**From:** [LPA TEAM](#)  
**To:** [Lauren Anderson](#)  
**Cc:** [LPA TEAM](#)  
**Subject:** RE: Greg Arms / Milestone WCMILLC project (SUB21-006, CAO21-004, & SEP21-022)  
**Date:** Monday, December 6, 2021 9:33:51 AM  
**Attachments:** [KC WTD Record Drawing Pages from 100259 North Mercer Island FM & Interceptor \(Sections 1 2 & 3\).pdf](#)  
[KC WTD Sewer One-Line 200 N Mercer Interceptor Trunk west.pdf](#)

King County (KC) Wastewater's 48" sewer runs along SE 22<sup>nd</sup> St but is not shown on the plan set, making it unclear on whether the proposed side sewer is connecting to the local sewer or to KC's sewer. Can you please confirm that this is a connection to the 8" local sewer?

MILESTONE PRELIMINARY SHORT PLAT

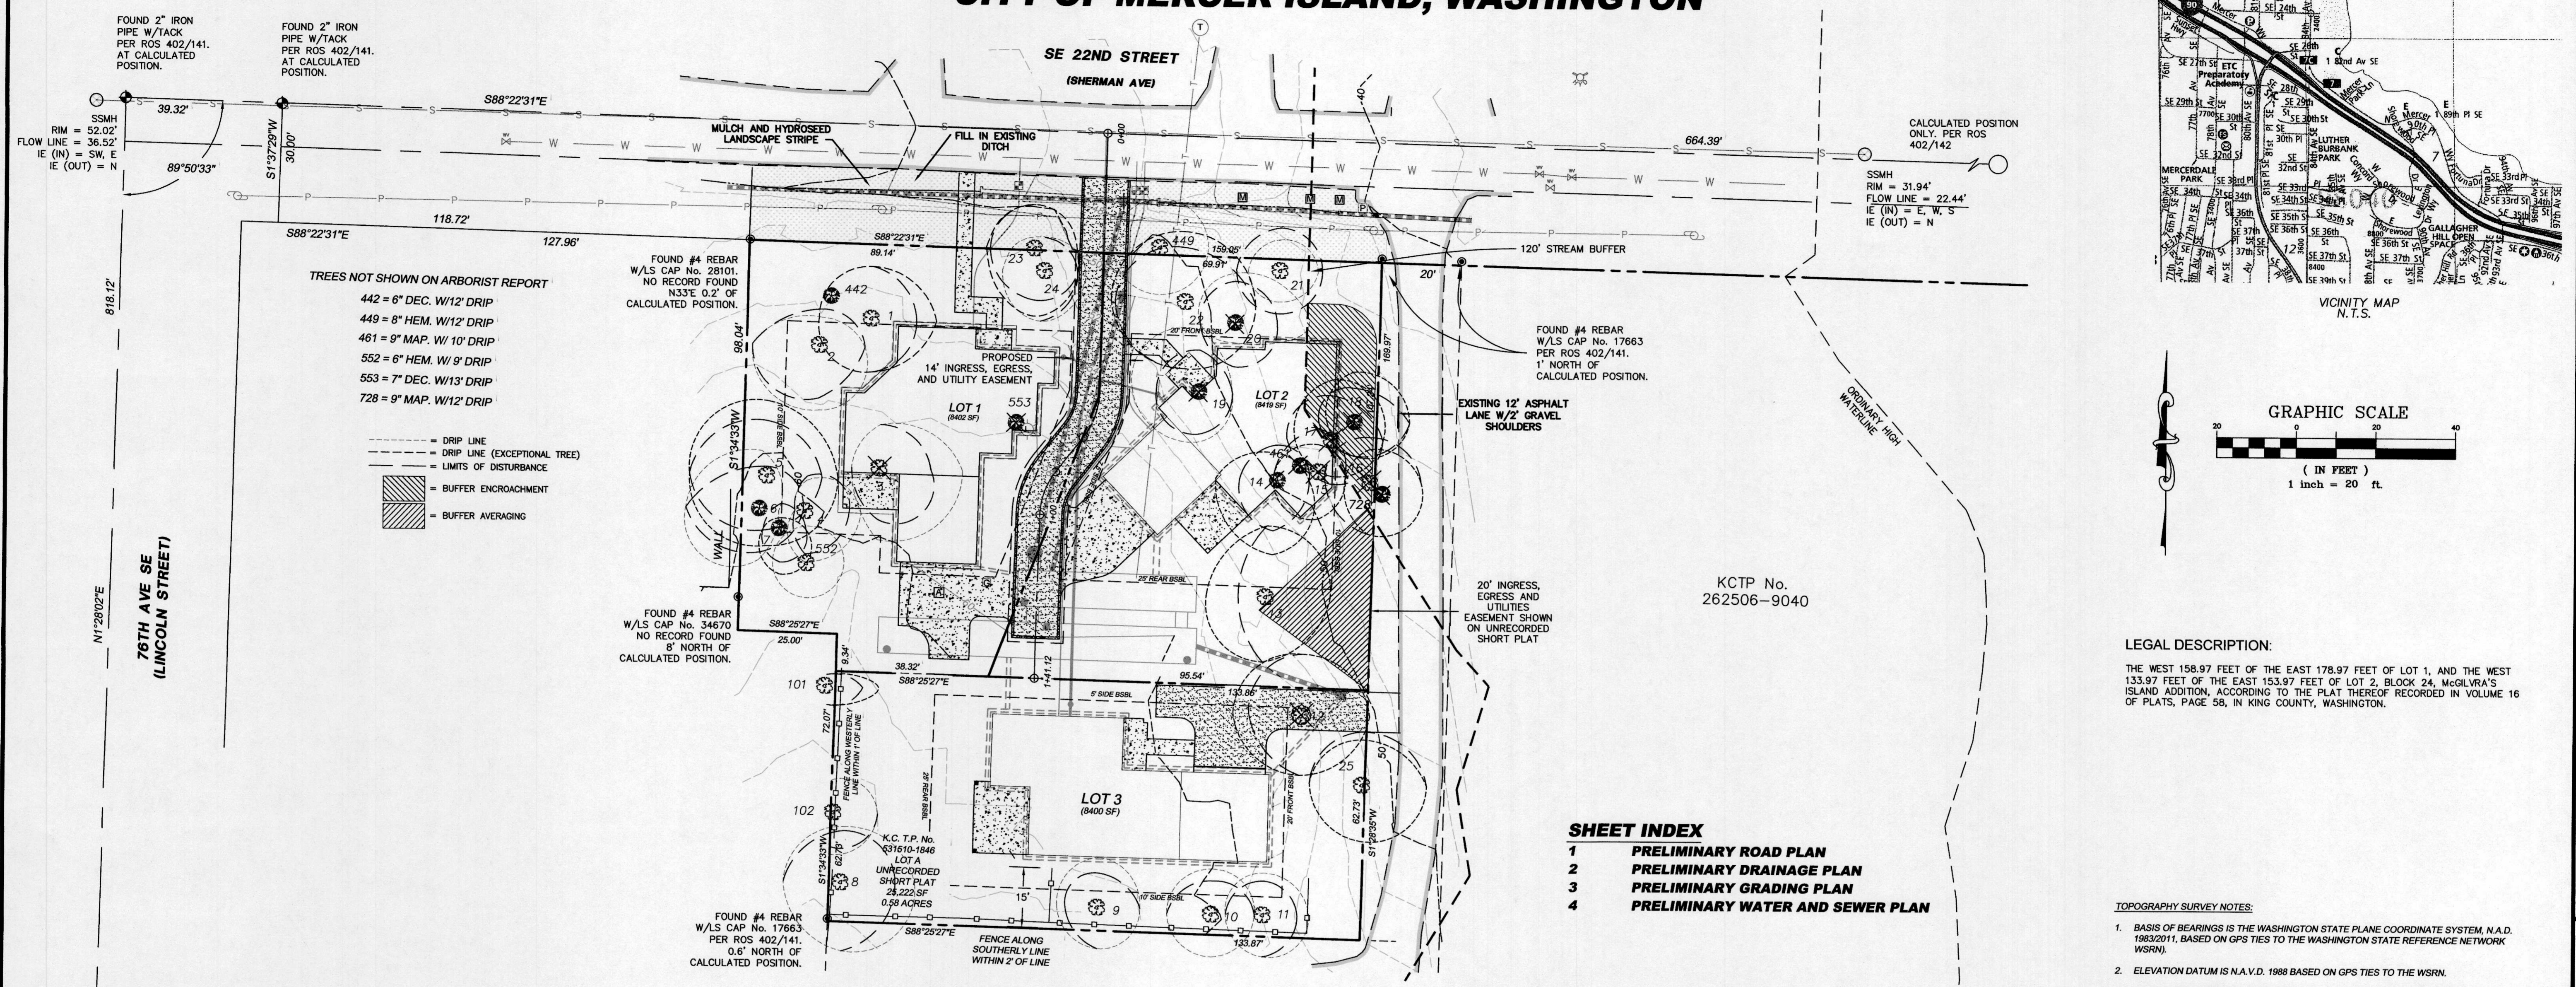
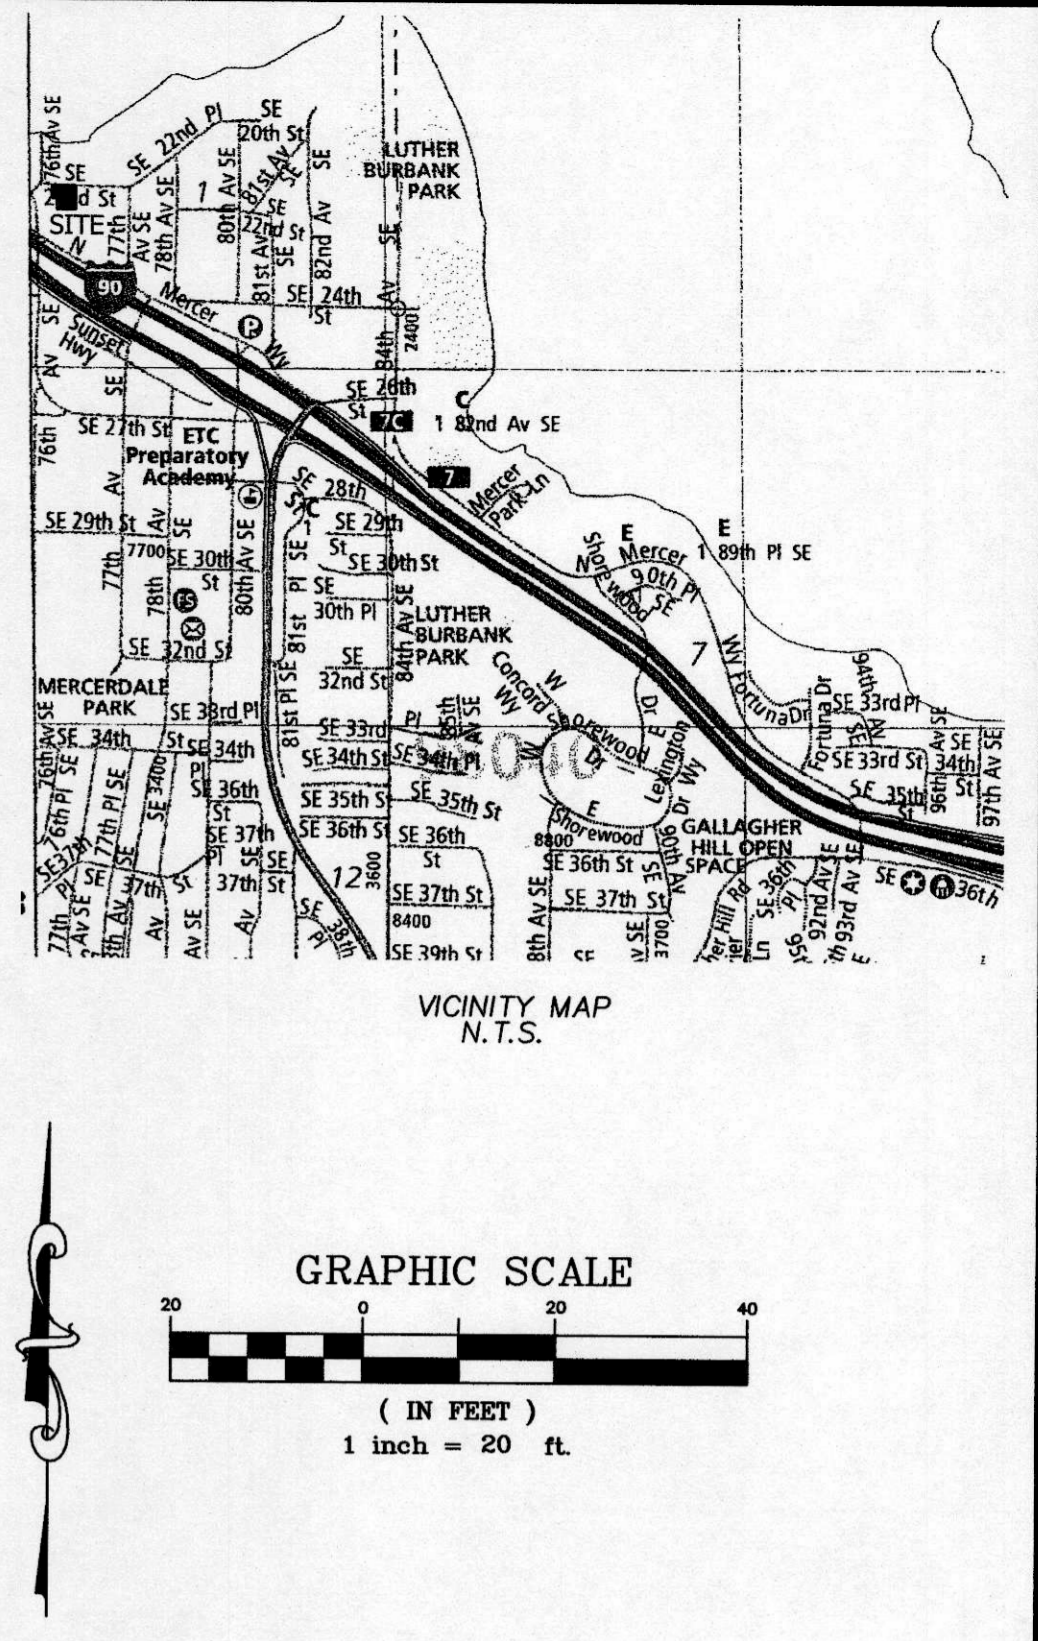
If it's not too late to make revisions to the plans, we request that KC's sewer be shown on the sewer plan and to include a profile view of the proposed sewer connection. Please also label the size of the sewer shown on the plans. Since KC's sewer is south of the local sewer, we want to ensure adequate clearance when the proposed sewer is crossing KC's sewer.
